DfI Roads

Consultation Response

Application Ref: LA11/2021/1210/TBA – Riverine Community Park &
LA11/2021/1211/TBA – Pedestrian and Cycle Bridge

Date of Response 15th April 2022

**Cross section D** Highlighting Through Proposed Carpark  
Scale: NTS

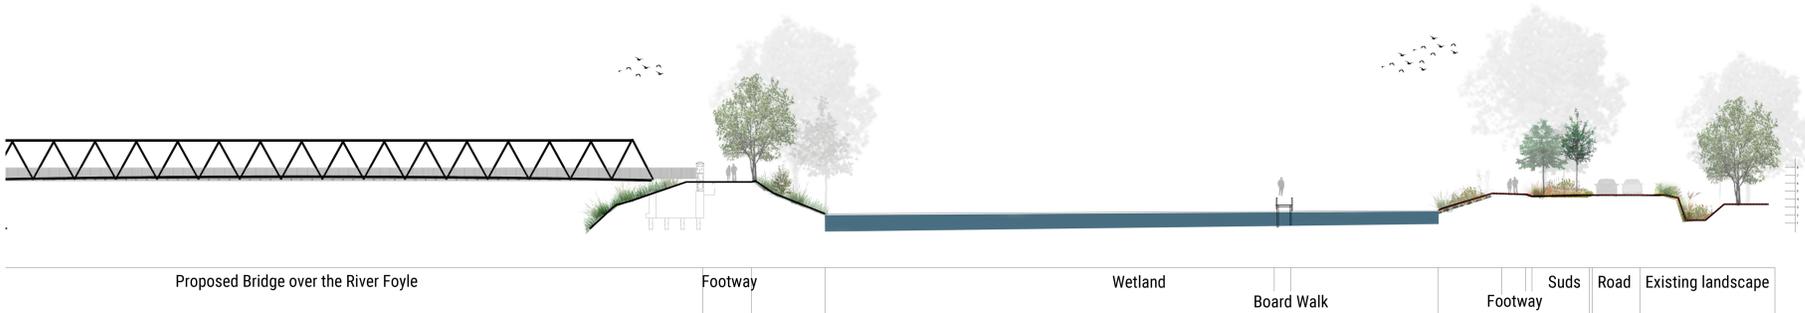
1. The submission has been reviewed with the 2022 environmental statement addendum for the A5 Western Transport Corridor (WTC).
2. This application follows on from two PADs submitted for this development by Derry City and Strabane District Council (DC&SDC). As previously, commented the layout clashes with the A5 WTC vesting line so is in conflict with AMP 4 of PPS 03.
3. The impact on the access from Lifford Road Roundabout to the proposed car park is intensification and not acceptable to DfI Roads as in conflict with AMP 3 of PPS 03.

A better vehicular access point should be considered for delivery of this development.
